Application for Removal or Variation of a Condition following Grant of Planning Permission or Listed Building Consent

Erection of a single storey side, rear and front extension including a front porch, following demolition of existing garage, porch, and conservatory.

76512/APP/2026/458

Condition 2 only

PROJECT 47 POTTER STREET NORTHWOOD			
TITLE PROPOSED FLOOR PLANS			
CLIENT SNEHAL PATEL			
DRAWN BY MI	CHECKED MI	PAPER A1	DATE 20.01.26
SCALE 1 : 100		PROJECT NUMBER PSN01	
DRAWING NUMBER A101			REV 5

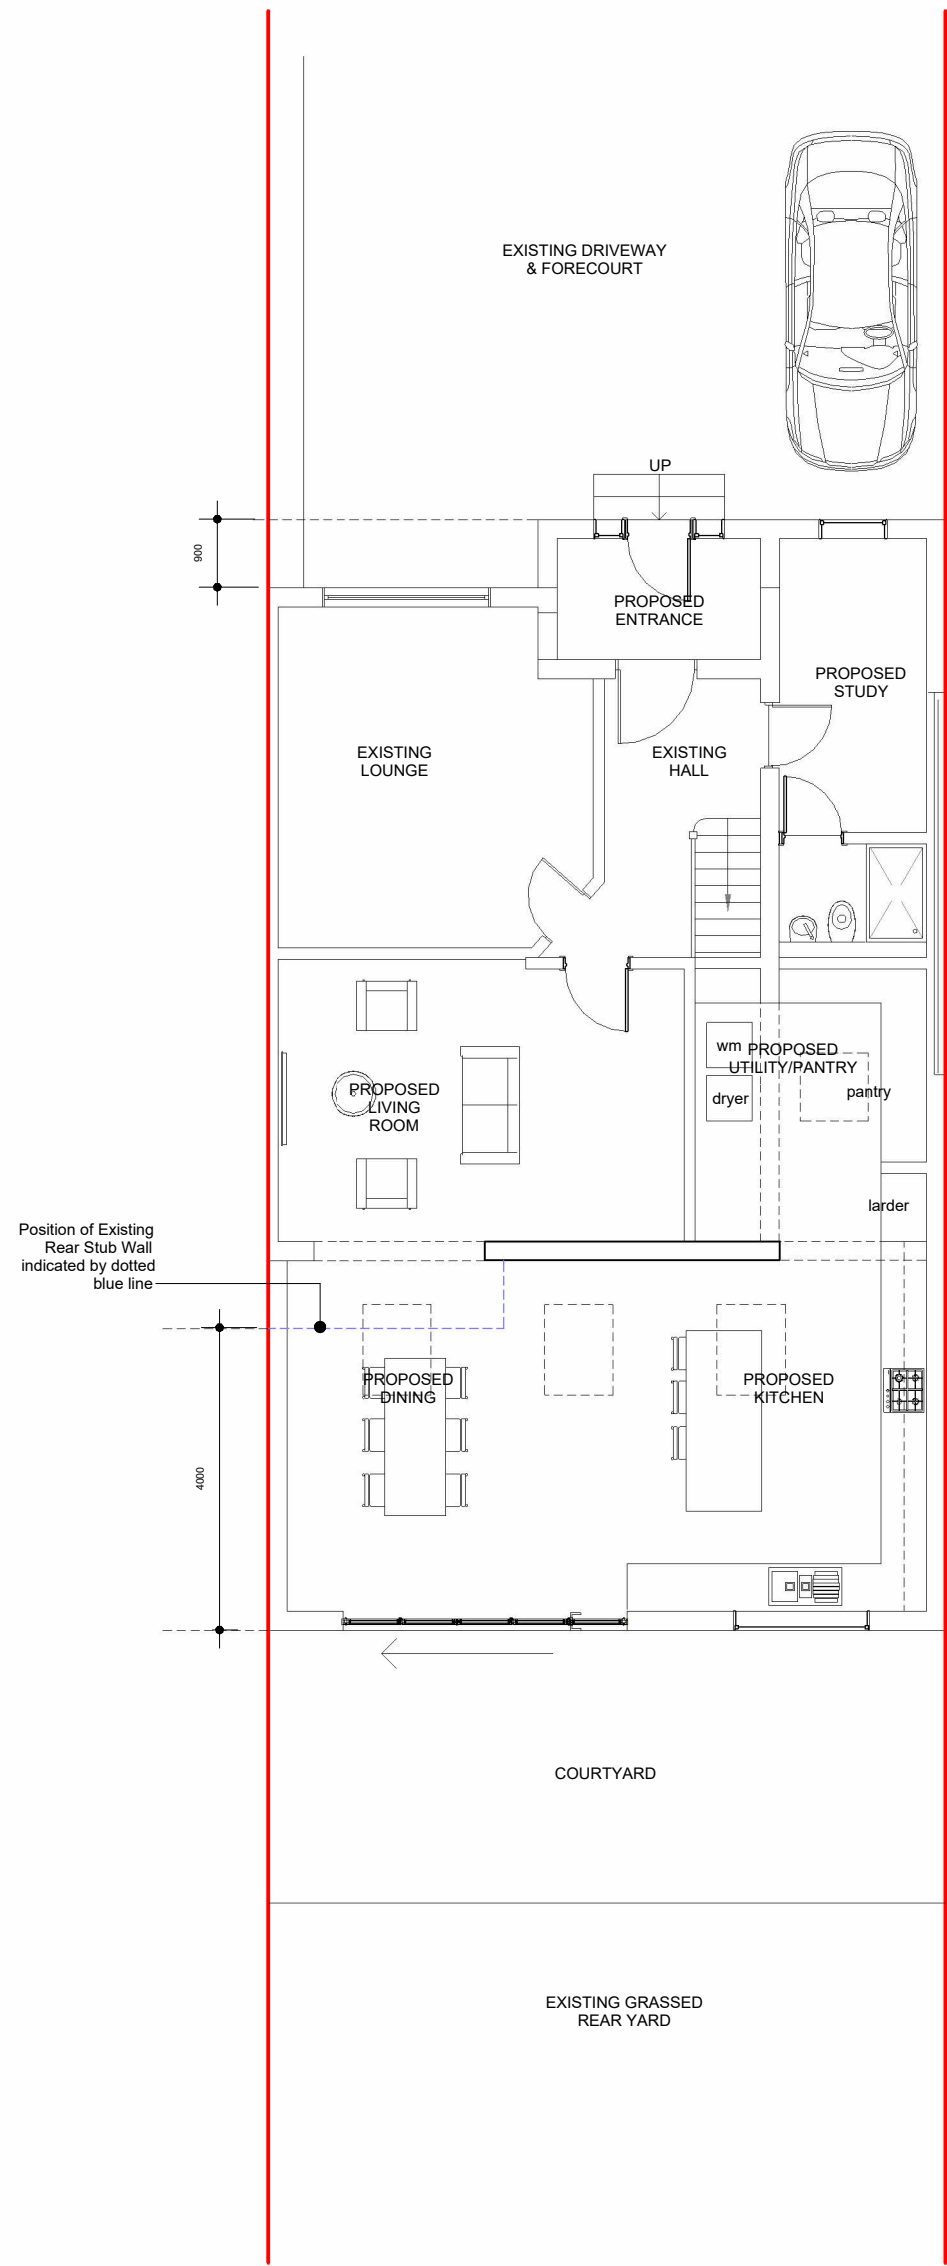
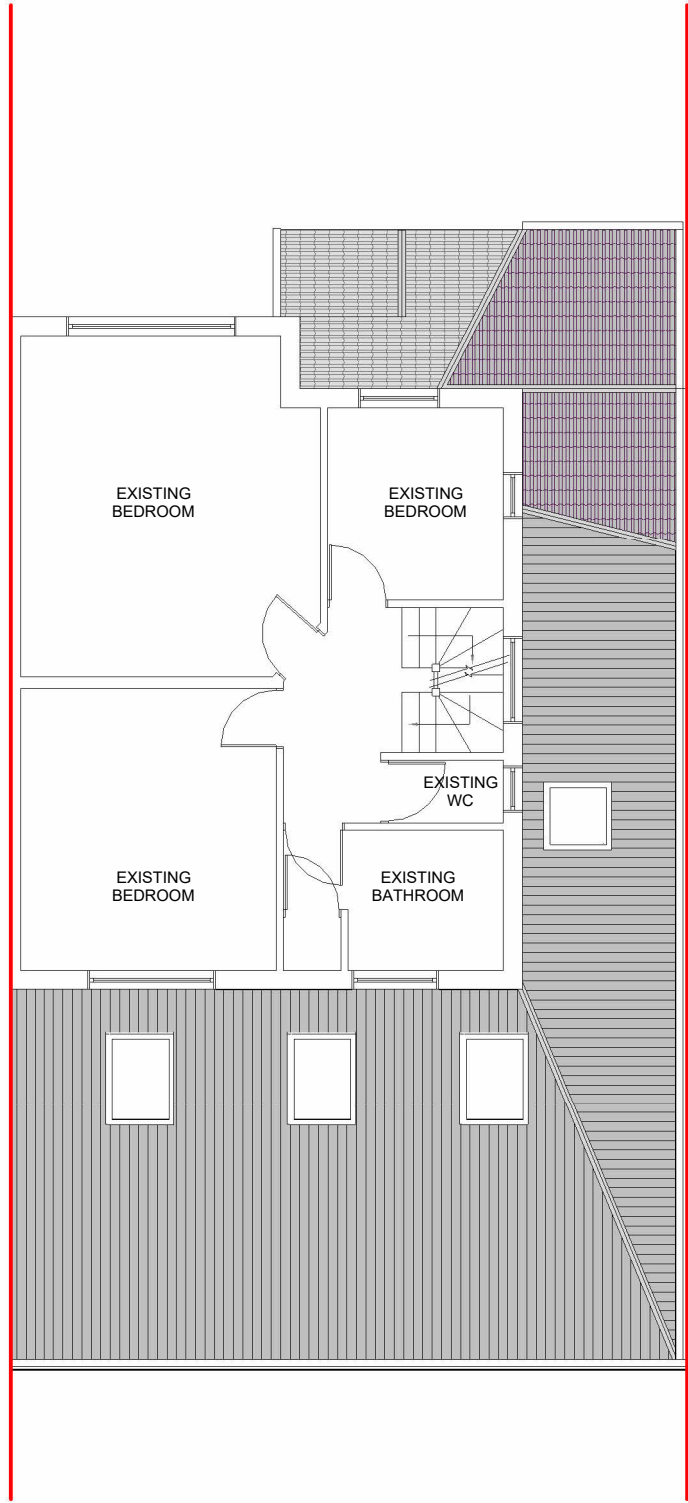
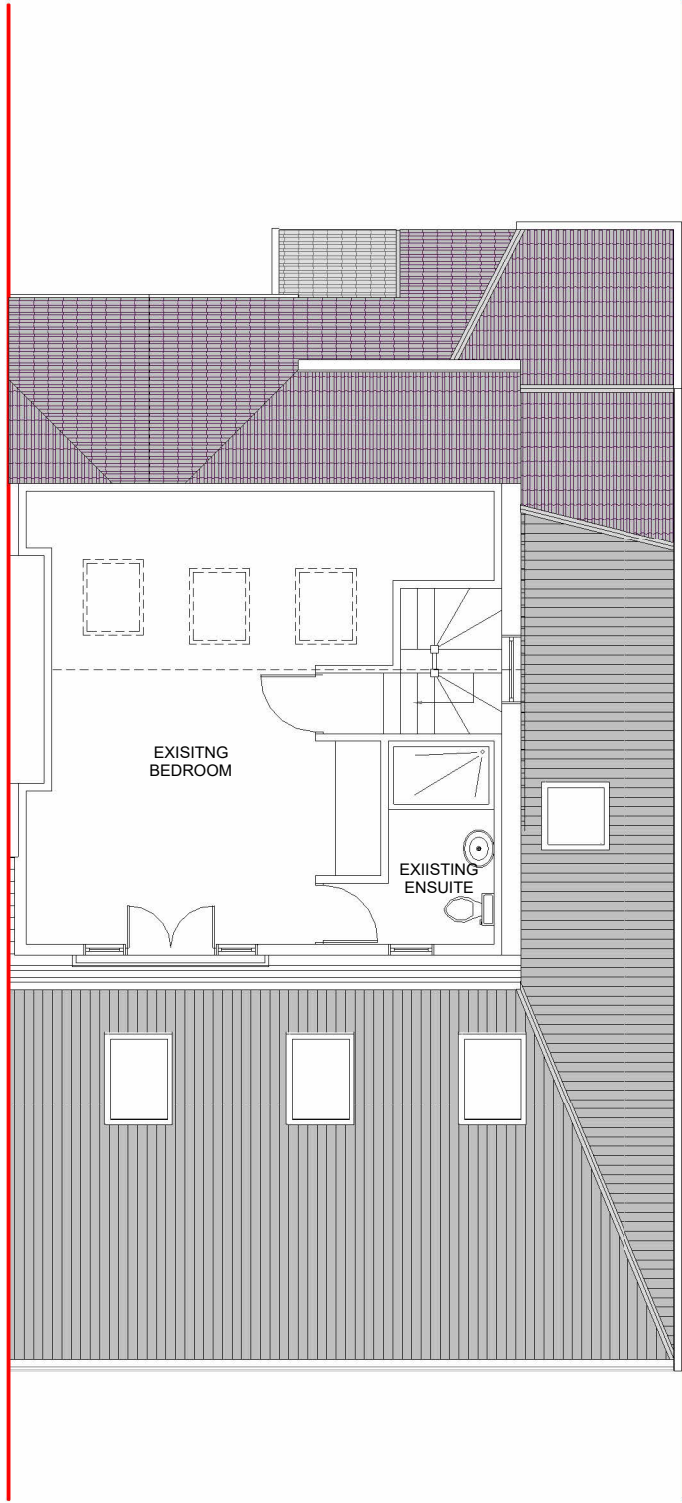
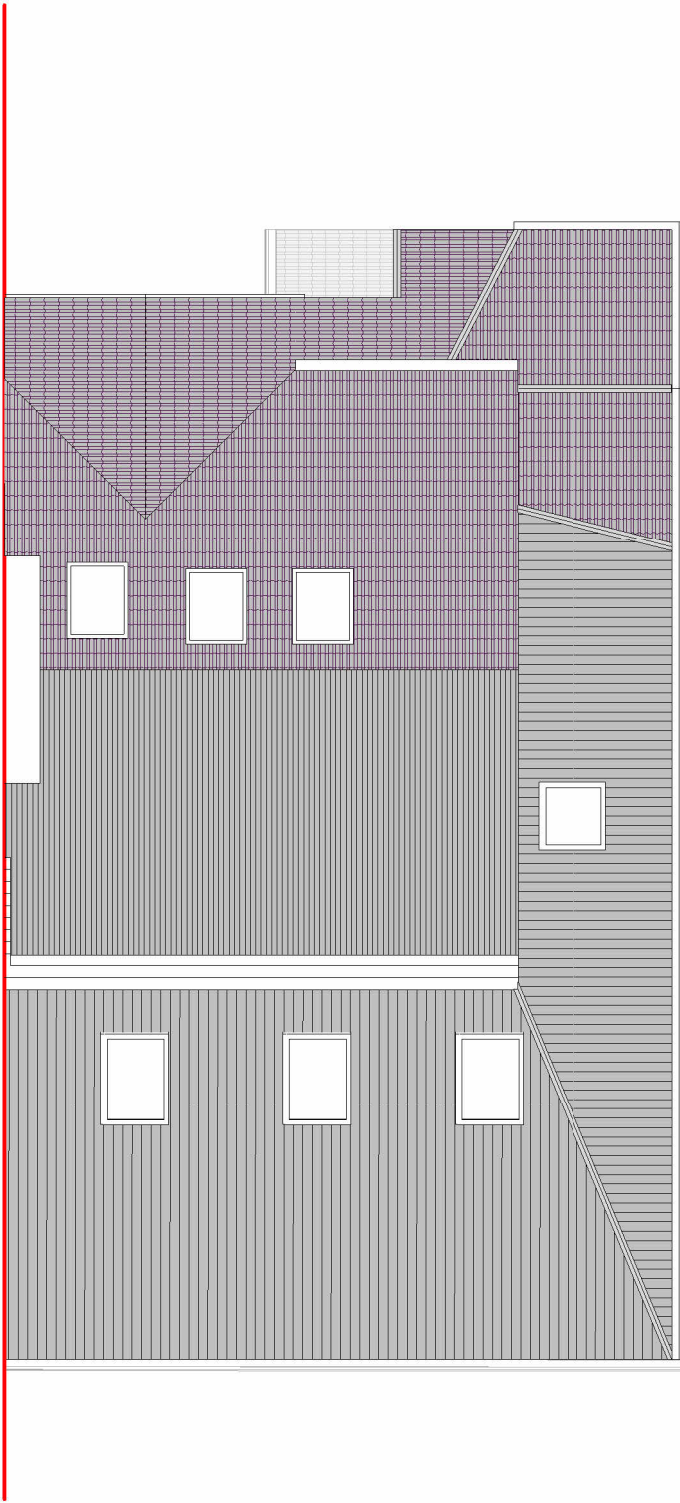
Condition 2 (Approved Plans) is sought to be varied to substitute three revised drawings (A090 Rev 3, A101 Rev 5, and A102 Rev 3) in place of the corresponding drawings approved under the original permission (reference 76512/APP/2026/458, granted 20th April 2026).

The variation is required to clarify the measurement baseline for the approved 4.00 metre single-storey rear extension depth. The approved drawing A101 Rev 4 does not explicitly define whether the 4.00 metre dimension is measured from the main rear wall of the principal structure or from the rear wall of the existing rear projection forming part of the original dwellinghouse (shared with No. 49 Potter Street).

The revised drawings clarify that the 4.00 metre depth is measured from the rear wall of the existing rear projection. This results in approximately 1.00 metre of additional built depth relative to the position shown on the originally approved drawings. The variation does not alter the description, height, width, external appearance, or materials of the approved development. All other conditions remain capable of compliance and are unaffected.
